Freedom Forever
Planset Revision Letter

5/28/2024
REV #1

BRIAN SAMUELS
59 BARK WAY , ANGIER, NC 27501

ROOF MOUNT PHOTOVOLTAIC SYSTEM

TOTAL ROOF AREA RIDGE SETBACK CALCS:
 TOTAL ROOF AREA: 1792.1 SQ FT
 SINGLE MODULE AREA: 21.65734022 SQ FT
 TOTAL NUMBER OF MODULES: 10
 TOTAL AREA OF MODULES: 216.57 SQ FT
 ROOF COVERAGE: 12.08%
 FIRE SPRINKLERS : NO

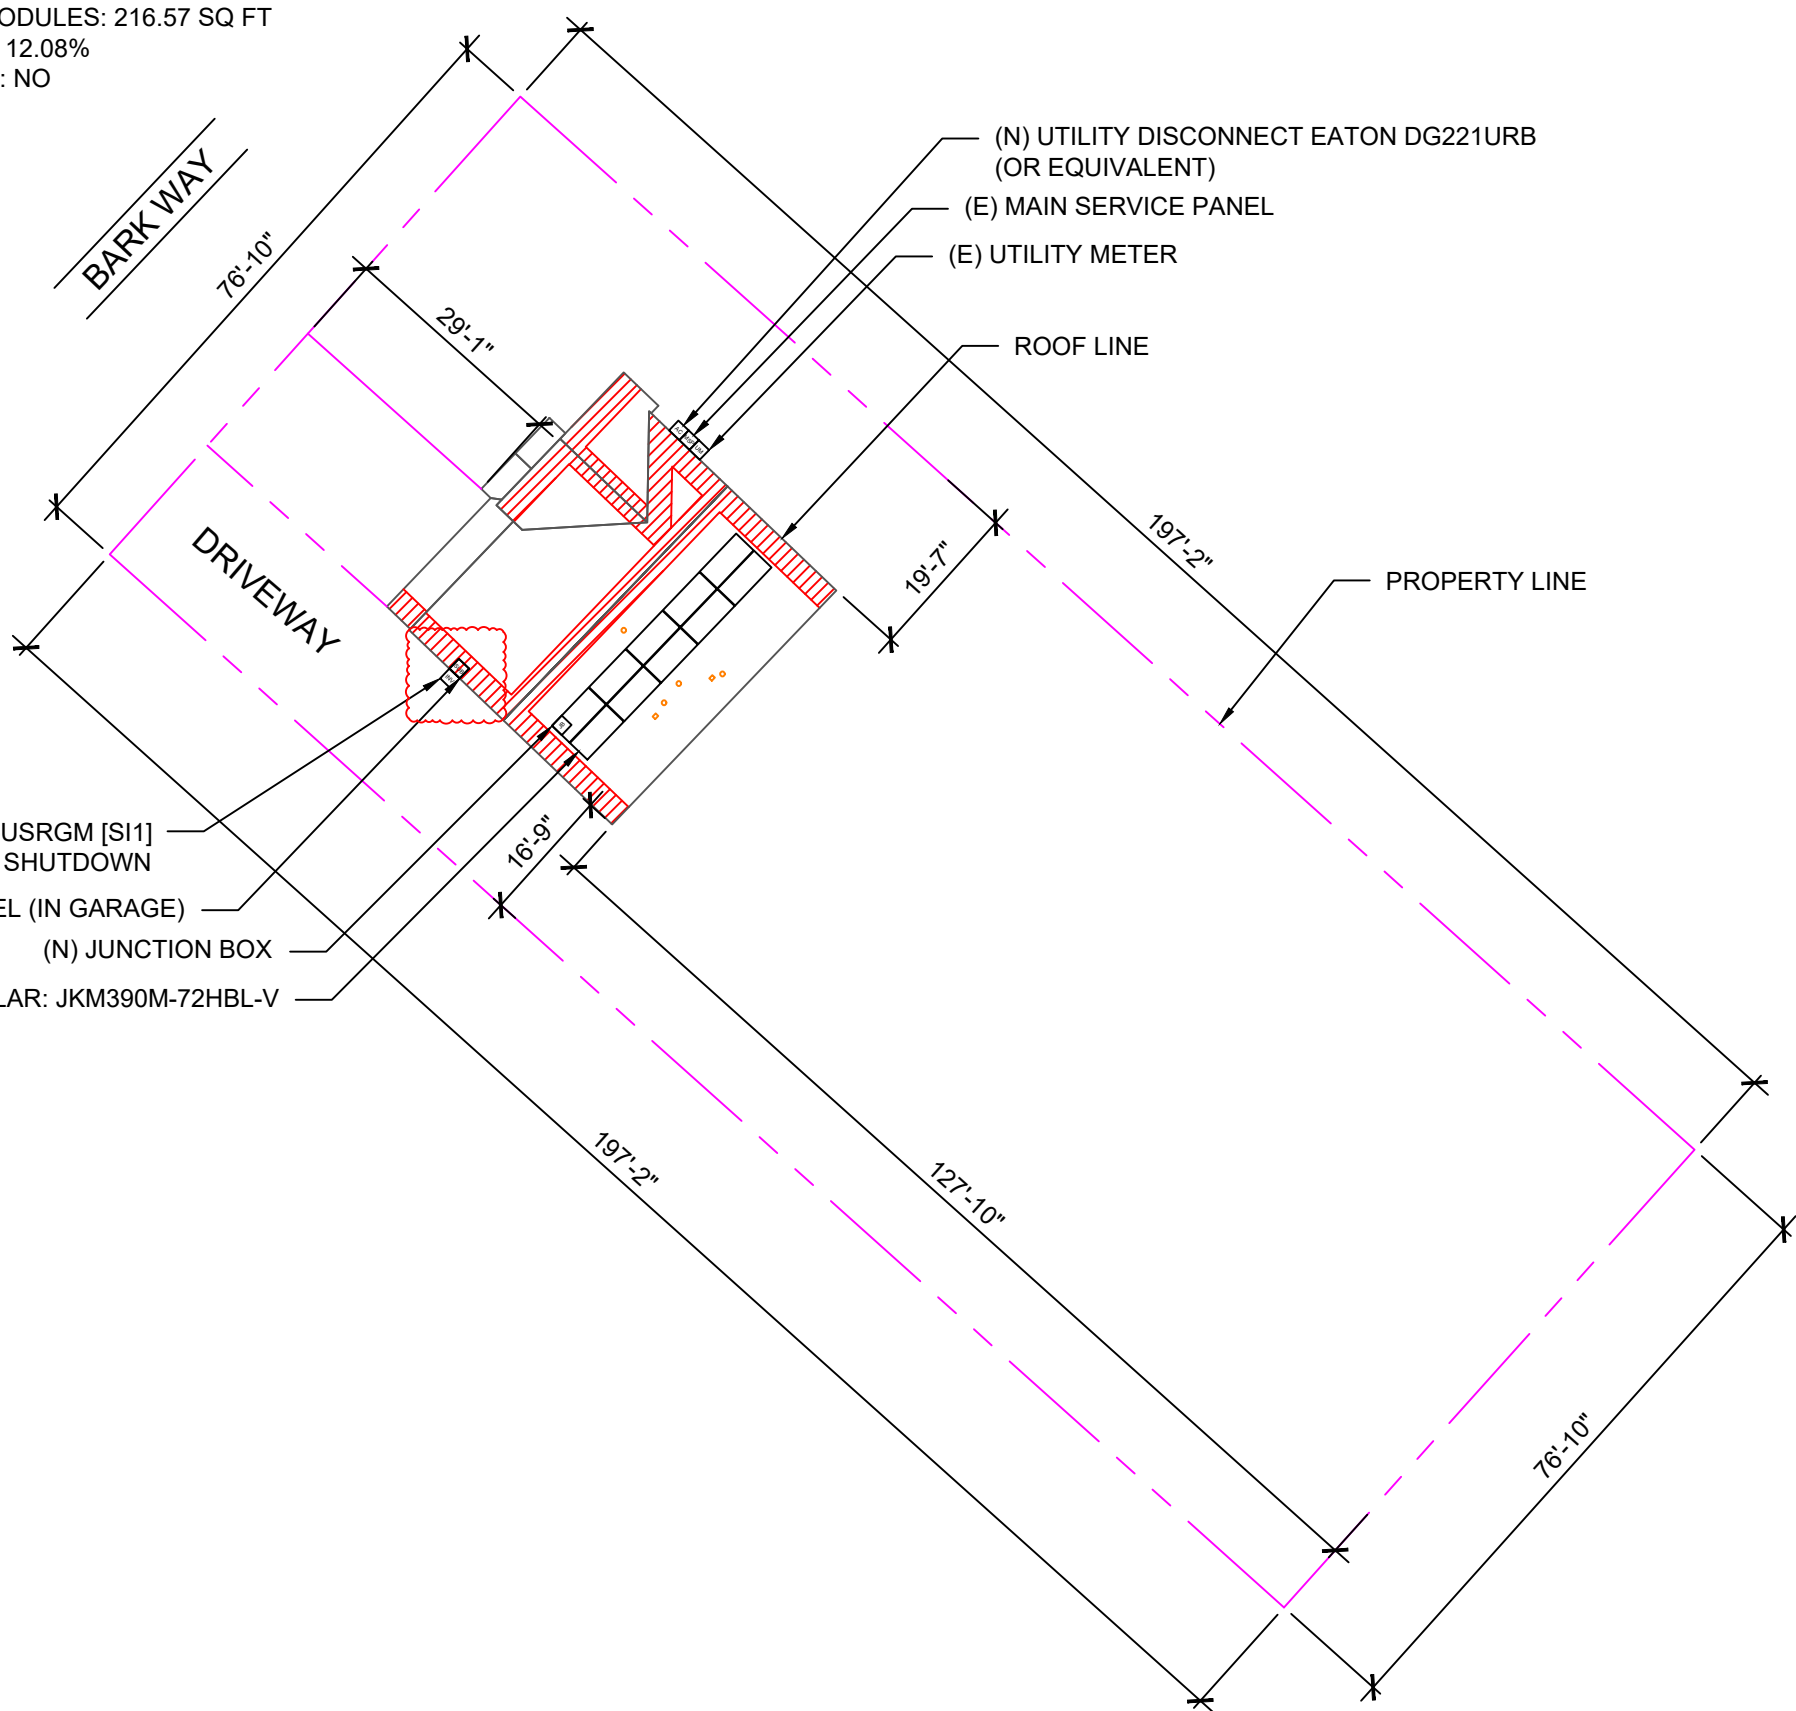
Inverter moved to the SW side of the home

All corresponding changes are notated on the plans by revision clouds.
